D & K Akers Subdivision

A Replat of Lot 3, Akers Acres, Subdivision 1,
Northeast Quarter, Section 32, Township 13 South,
Range 65 West of the 6th P.M.,
El Paso County, Colorado

Vicinity Map

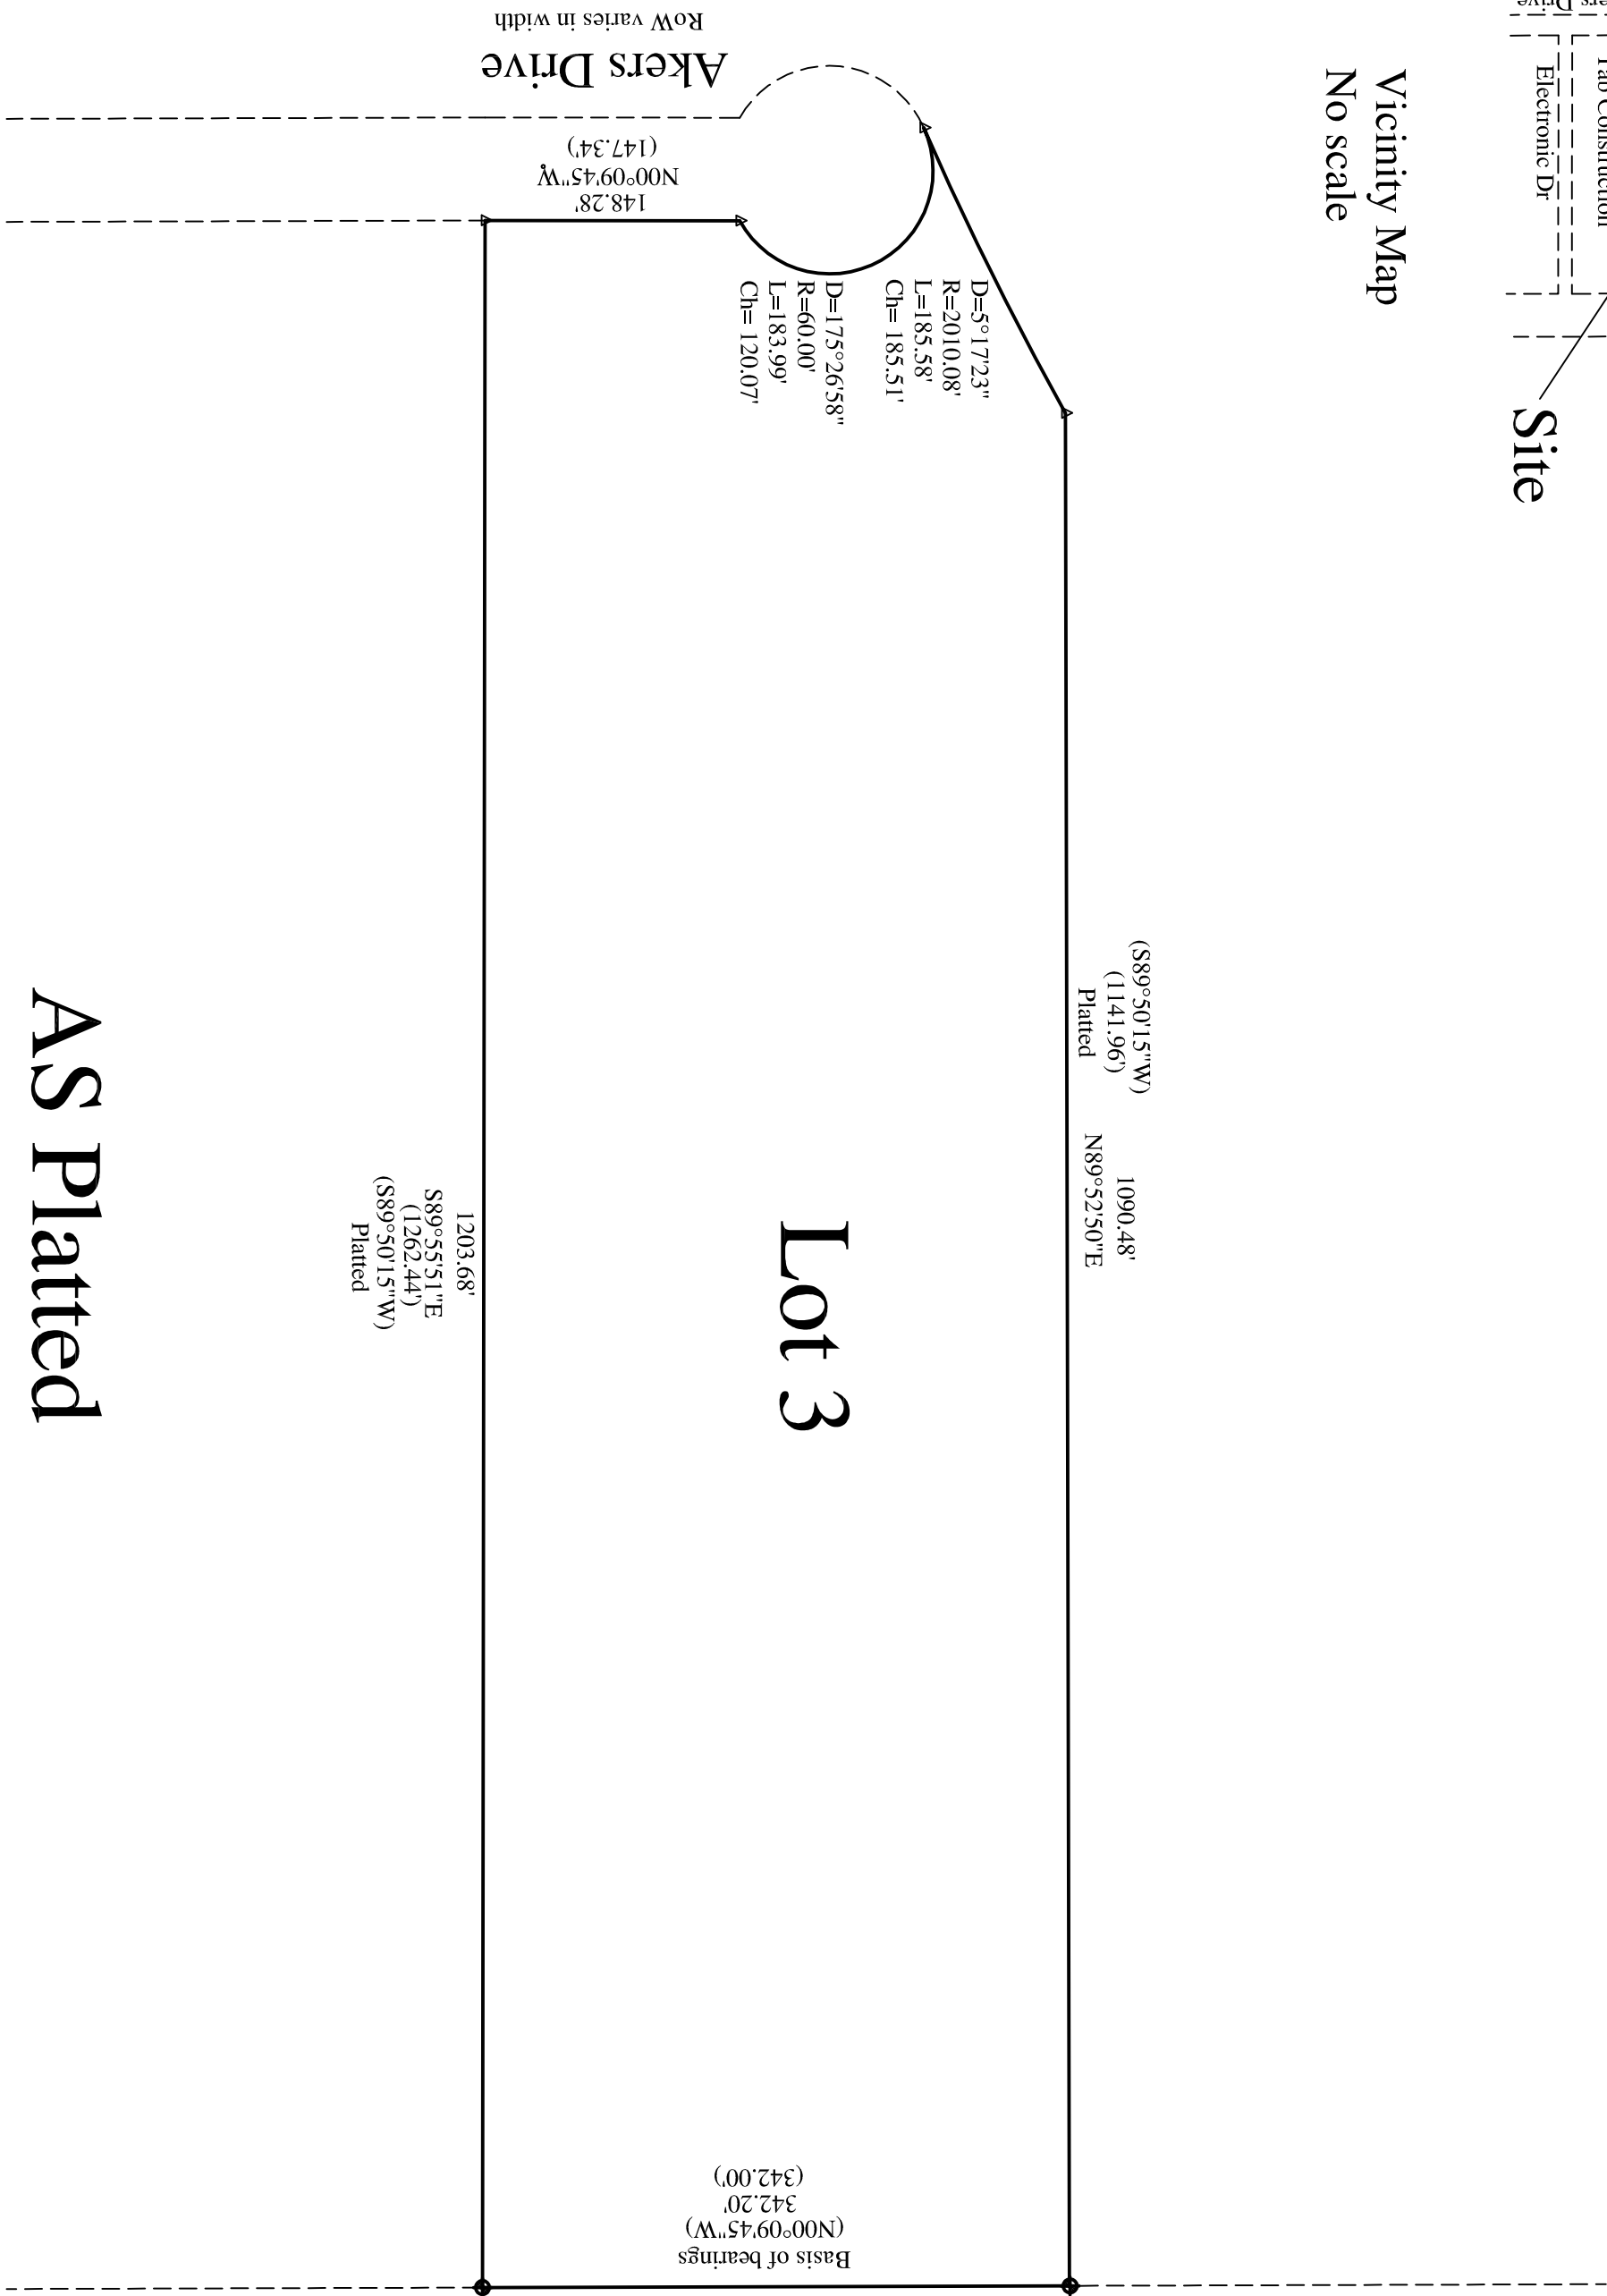
Vicinity map should show the subdivision in relation to section lines and existing or proposed streets within one mile.

Show names of all adjoining subdivisions with dotted lines of abutting lots. If the adjoining land is unplatted, it should be shown as such.

Include labels reading "Not a part of this subdivision" and dashed lines delineating areas that do not constitute a part of the subdivision.

Names of adjoining subdivisions added

Vicinity Map Revised as requested

"Not a part of this Subdivision" added to labels

As Replatted

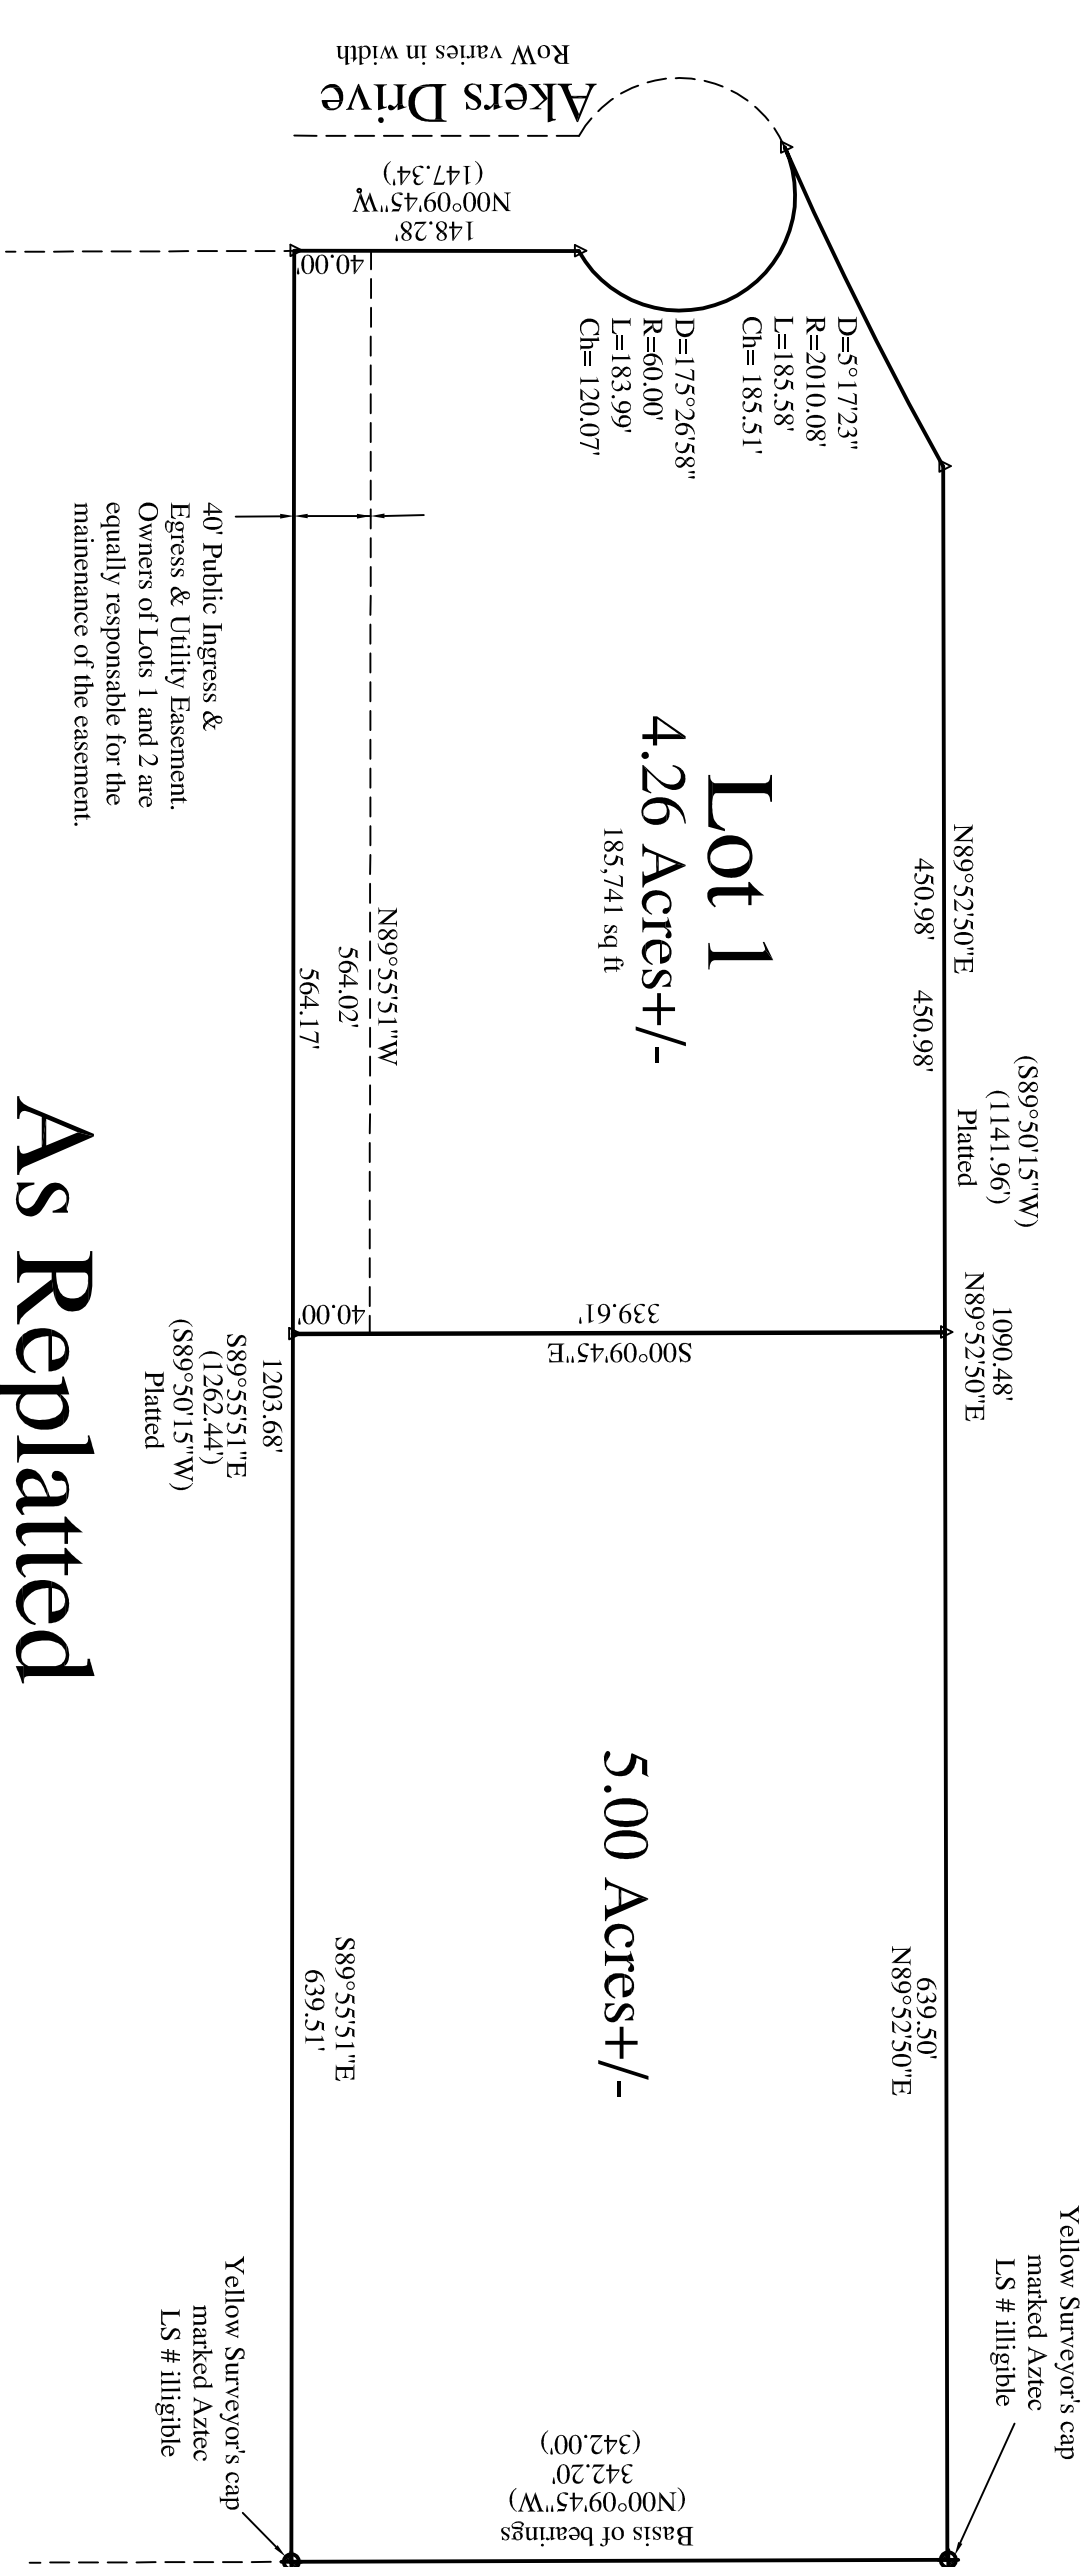
Please show all existing and proposed easements. There are several easements on this property - none of which are depicted.

Shared driveway exceeds 150 and is considered a fire apparatus access road. A turnaround shall be provided. Coordinate with the Fire Chief for the turnaround location and configuration. Adjust the shared access easement accordingly to accommodate the turnaround.

Show ROW easement along Marksheffel per Plat # 2510

Easements added as requested

We coordinated with the Fire Chief and a turnaround will be provided with the final site plan. Not required with this plan.

Shared Access Easement adjustment is not required.

ROW easement added as requested.
